**RE: FORMER SCOTTISH HOSPITAL, 2 COOPER STREET PADDINGTON NSW 2021 (MP10_0016)
POTENTIAL HERITAGE ISSUES: SECTION 75W APPLICATION**

We write on behalf of the Owner, Presbyterian Aged Care, in support of heritage aspects of the proposed Section 75W application to MP10_0016, as shown in the following drawings prepared by Conybeare Morrison International Pty Ltd:

Heritage Building - Level 5

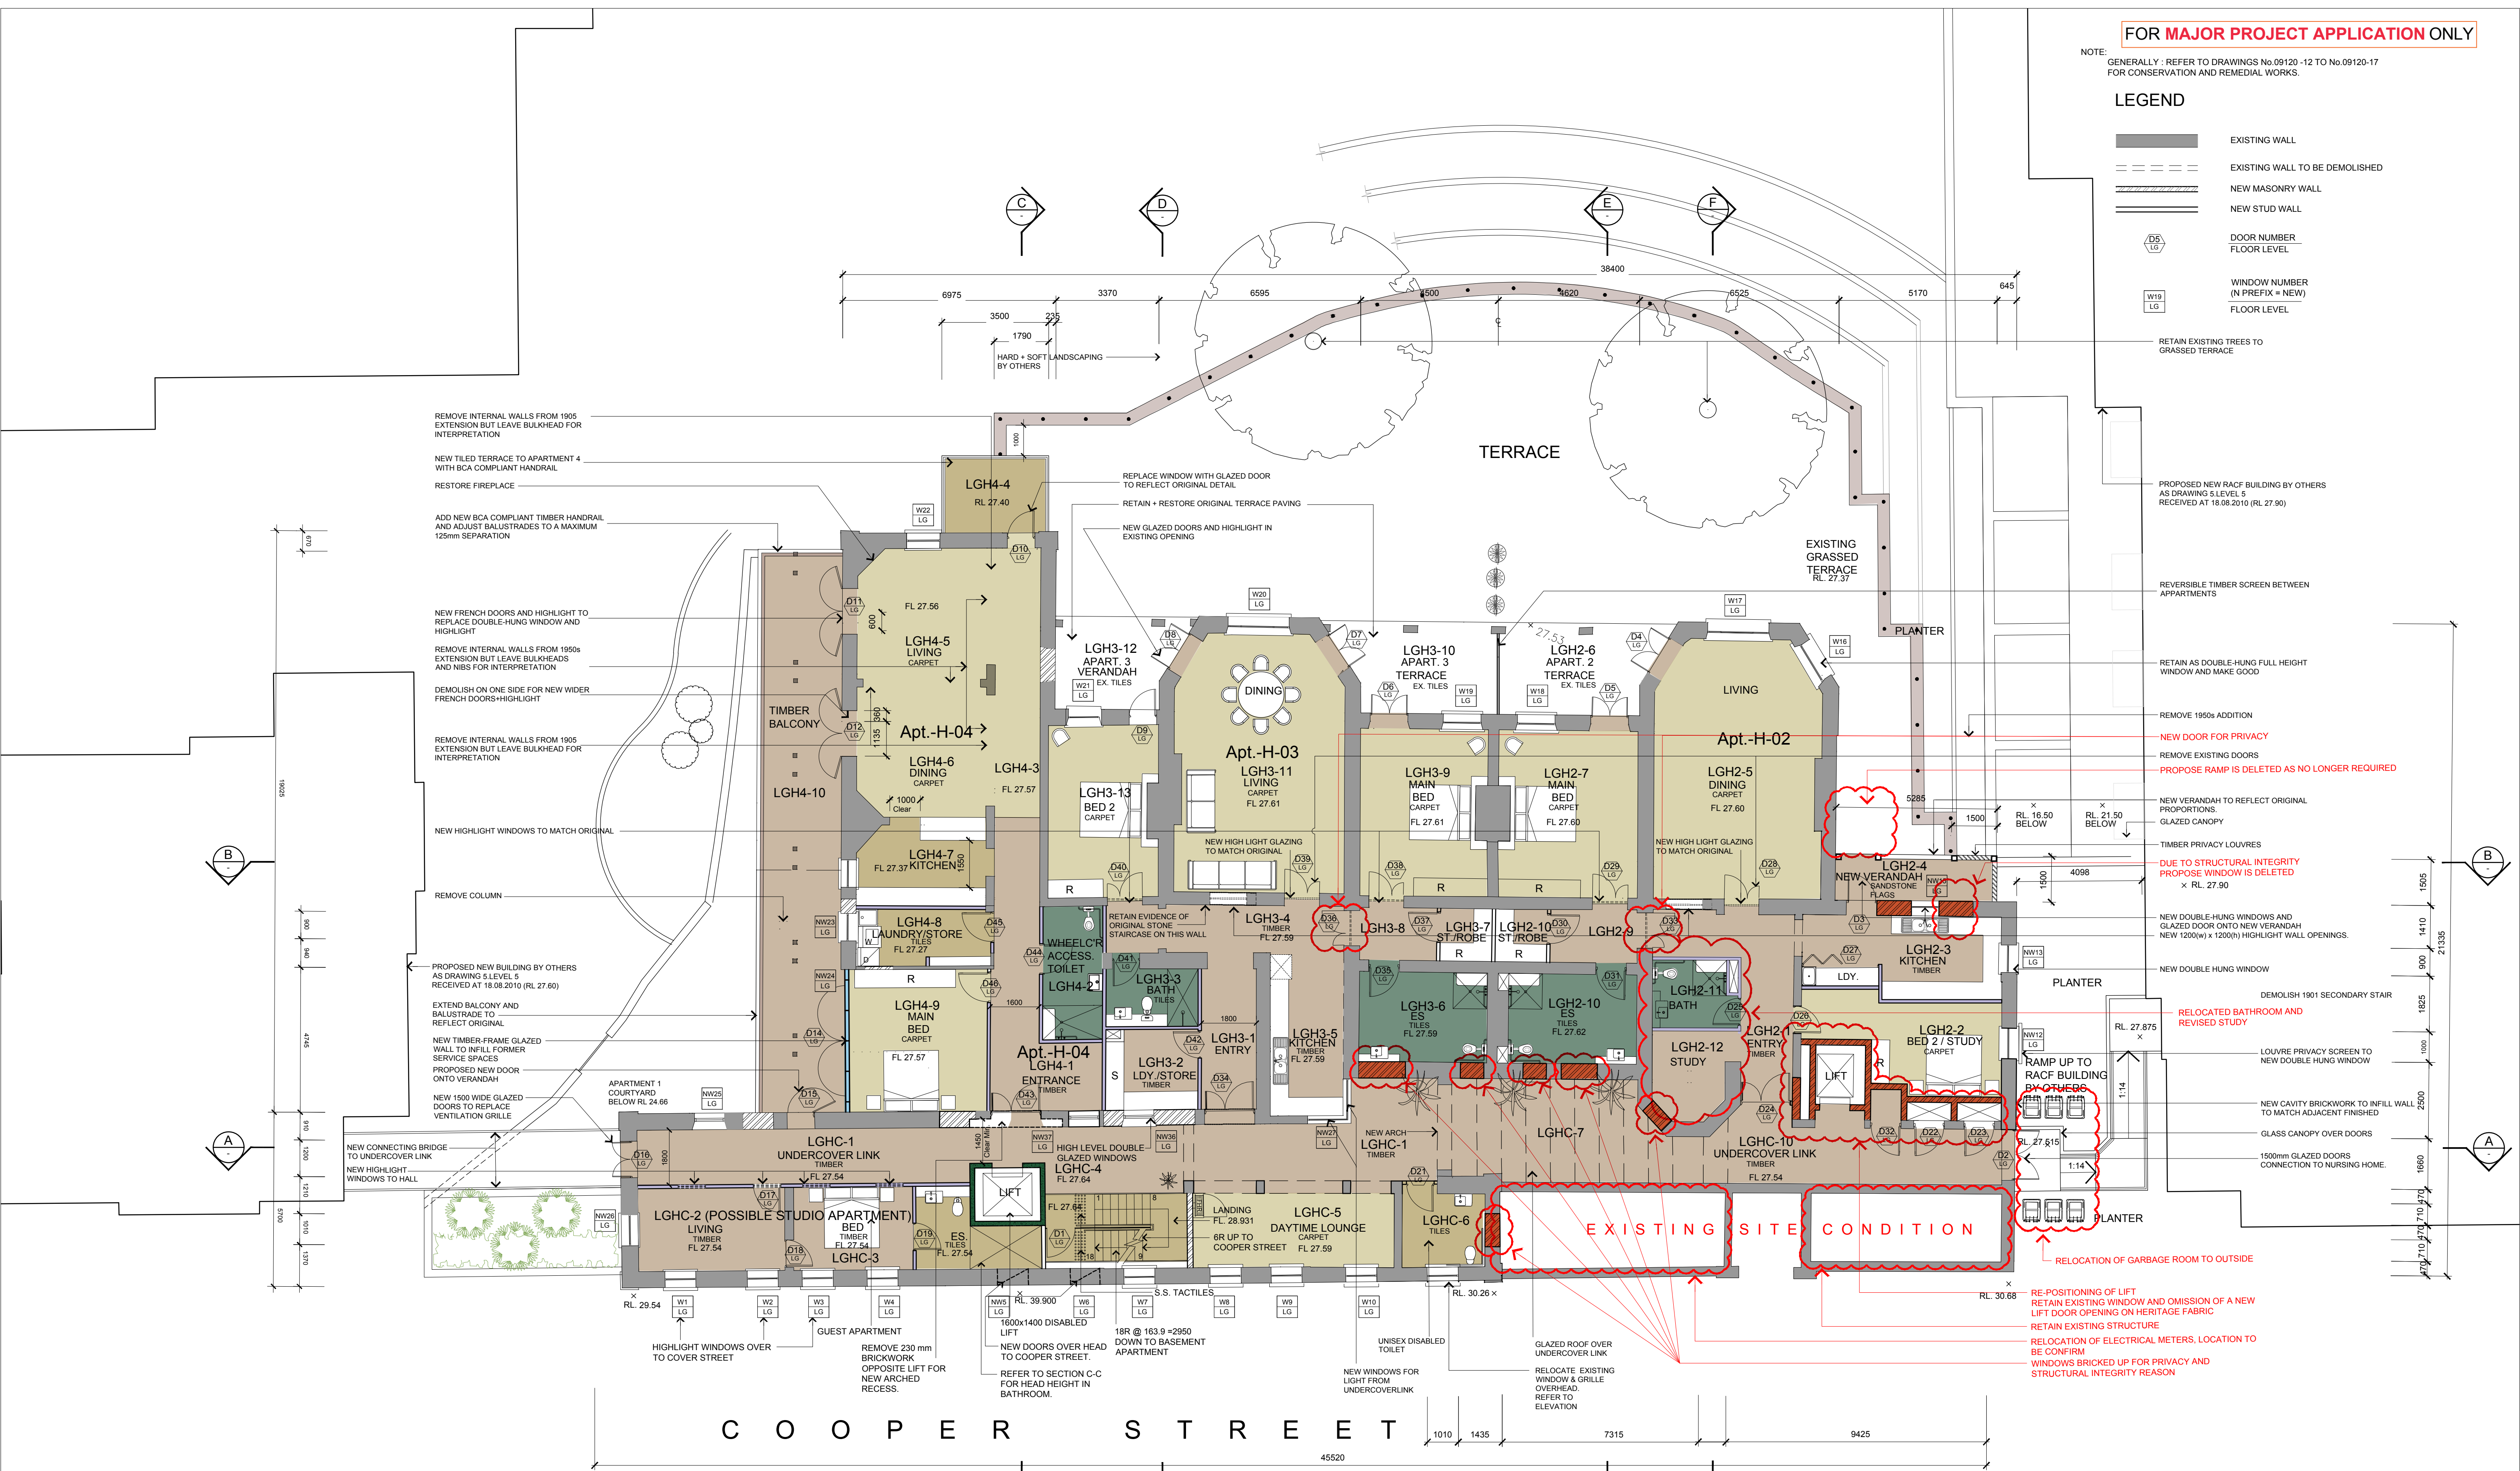
PROPOSED CHANGE	HERITAGE IMPACT
<p>Level 6 and Level 5 Relocate Lift 9 to internal location as shown (Drawing Nos. 2006067-DA431 and DA432).</p>	<p>Acceptable heritage impact: relocation of Lift 9 is required to enable additional underpinning at basement level.</p> <p>The relocation of Lift 9 to an internal space as shown would result in the retention of an external window and it would be relocated to a space identified in the CMP as being 'intrusive' and would not affect significant heritage fabric. The space was constructed as an operating theatre, and subsequently altered in the 1990s to provide a corridor leading to the former north east wing (now demolished). The lift overrun would not be visible at roof level.</p>
<p>Level 6 Delete proposed new windows NW13/G, NW 15/G and NW 18/G from south elevation.</p>	<p>Negligible heritage impact: reduces adverse impacts on heritage fabric.</p>

<p>Level 6 Delete window W 16/G from south elevation.</p>	<p>Adverse heritage impact-removal of significant original fabric.</p>
<p>Level 6 Delete proposed new window NW25/G from north elevation.</p>	<p>Negligible heritage impact: reduces adverse impacts on heritage fabric.</p>
<p>Level 6 Retain W19/G as a window: do not adapt as new entrance.</p>	<p>Positive heritage impact. This action retains original fabric and the established fenestration pattern of the Cooper Street elevation.</p>
<p>Level 6 Relocate stud wall forming west wall of space GH5-6 (Bed 3)</p>	<p>Negligible heritage impact: does not affect significant heritage fabric.</p>
<p>Level 6 Delete stud wall forming west wall of space GH5-5 (Bed 2)</p>	<p>Negligible heritage impact: does not affect heritage fabric.</p>
<p>Level 6 Retain masonry wall forming west wall of GH5-1 (Entry)</p>	<p>Negligible heritage impact: involves the retention of original fabric.</p>

<p>Level 5 Delete window W11/LG from east wall of space LGHC-6 at engineer's request.</p>	<p>Acceptable heritage impact: the window would be infilled with masonry set back from the face of the internal and external walls to interpret the original location of the window.</p>
<p>Level 5 Delete proposed new windows NW29/LG and NW30/LG from south wall of space LGH3-6.</p>	<p>Negligible heritage impact: reduces adverse impacts on heritage fabric.</p>
<p>Level 5 Delete windows W31/LG and W32/LG from south wall of space LGH2-12 as requested by engineer to maintain structural integrity of original building.</p>	<p>Acceptable heritage impact: the window would be infilled with masonry set back from the face of the internal and external walls to interpret the original location of the window.</p>

Level 5 Delete windows NW33/LG, NW34/LG and NW35/LG from south wall of LGH2-13.	Negligible heritage impact: reduces adverse impacts on heritage fabric.
Level 5 Delete ramp located to the north of space LGH2-4.	Negligible heritage impact: does not affect heritage fabric.
Level 5 Delete proposed new window NW14/LG to north wall of LGH2-5 on engineers' advice to maintain structural integrity of existing walls.	Negligible heritage impact: reduces adverse impacts on heritage fabric.
Level 5 Relocation of electrical meters.	Acceptable heritage impact: would not be visible on the exterior of the building; located in area designated as 'intrusive'.
Level 5 Relocation of garbage room to outside.	Negligible heritage impact: would be situated below Cooper Street level and would not adversely impact on views to the former Scottish Hospital.
Level 5 Construct new shower room (Space LGH2-11) with stud walls; construct new riser servicing levels 5 and 6.	Acceptable heritage impact: other locations within the apartment were considered and rejected as they required introduction of additional service lines. The location shown would enable services to space LGH2-10 to be adapted to serve space LGH2-11.

DRAWING TITLE
North-South Elevations
DRAWING No
DA 435

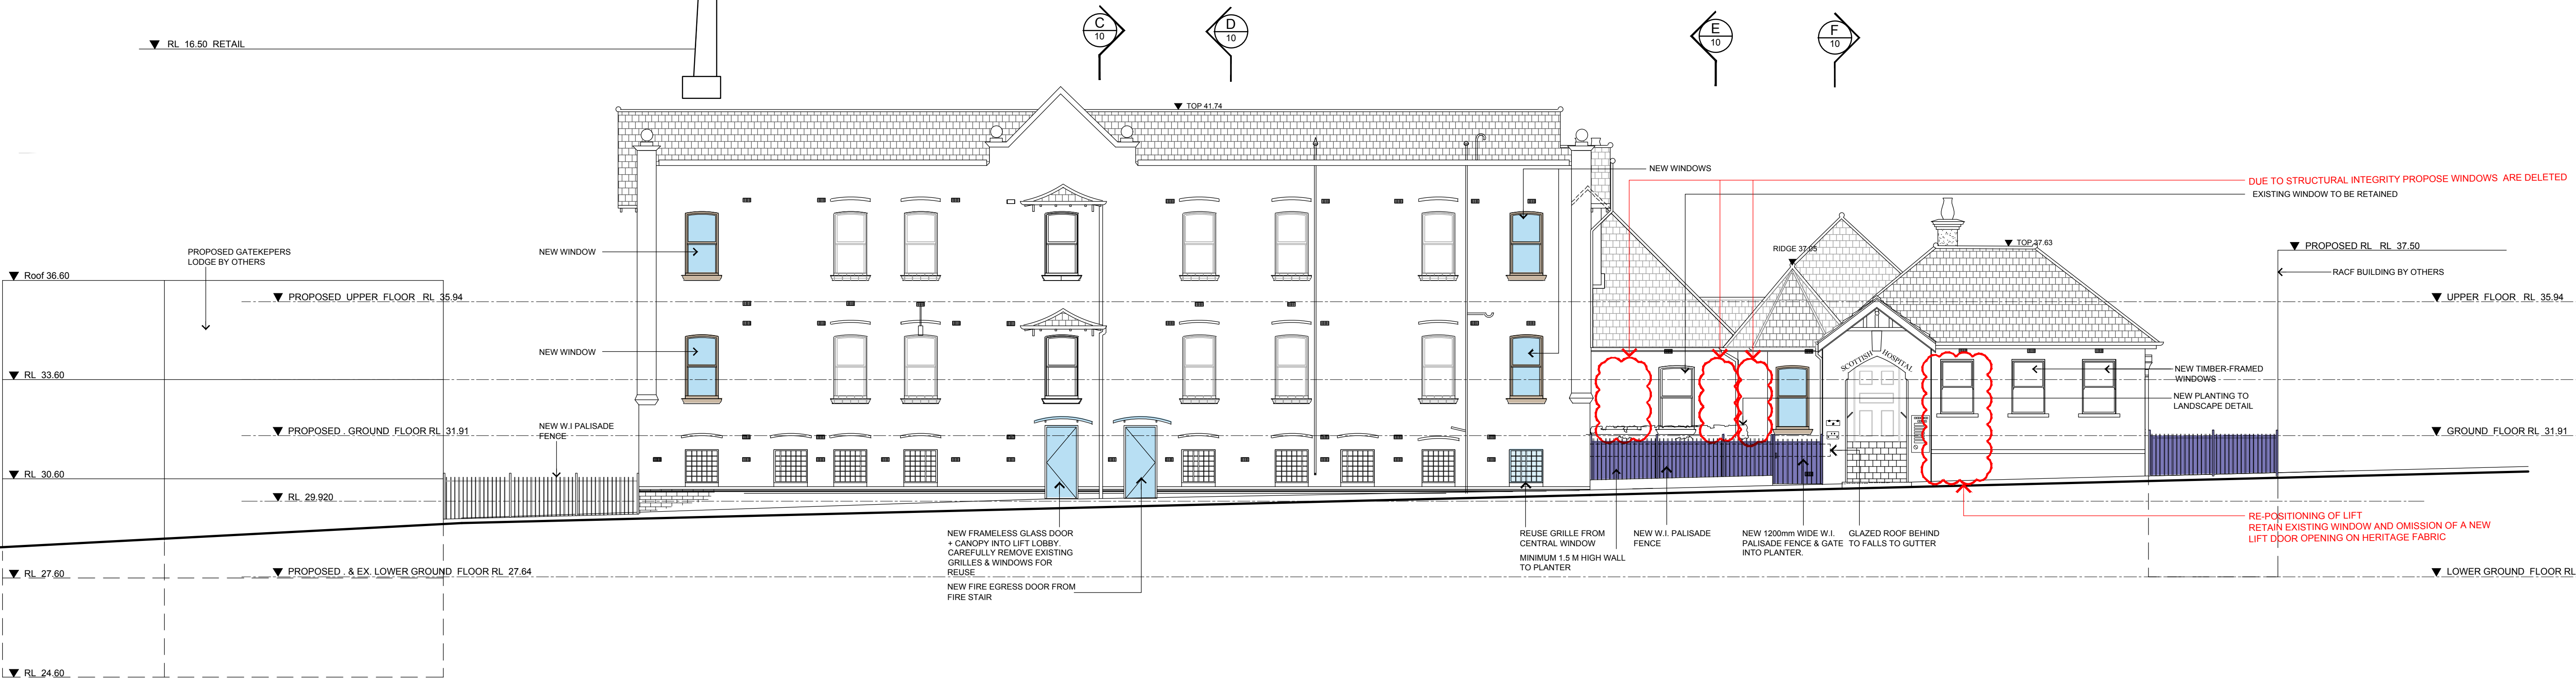
- The relocation of Lift 9 would have a positive heritage impact on the Cooper Street elevation. Window: the window intended for adaptation as an entrance to Lift 9 would be retained in situ, without further modification.

DRAWING TITLE
Heritage Building - Level 6
DRAWING No
DA 432

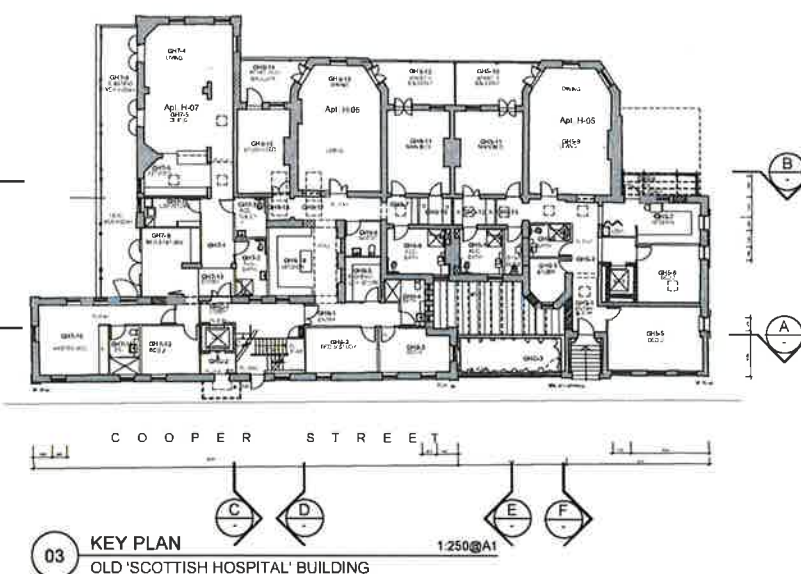
<p>Level 6 Adapt proposed north stud wall of space GH5-3 to create accessible lift lobby.</p>	<p>Negligible heritage impact: does not affect heritage fabric.</p>
<p>Level 6 Increase the size of opening in west masonry wall forming the west wall of space GH5-3</p>	<p>Acceptable heritage impact provided nibs are retained and a section of masonry above the opening. Details of new reveals and architraves are to match existing joinery details confirmed on site by heritage specialist on site.</p>
<p>Level 6 Construct new shower room Space GH5-4 with stud walls; construct new riser servicing levels 5 and 6.</p>	<p>Acceptable heritage impact: other locations within the apartment were considered and rejected as they required introduction of additional service lines. The location shown would enable services to spaces GH5-1 and GH5-13 to be adapted to serve space GH5-4.</p>
<p>Level 6 Adapt proposed study (space GH5-3)</p>	<p>The new space would be formed by stud walls and would not involve further removal of heritage fabric. A new ceiling would be installed to improve the proportions of the space.</p>
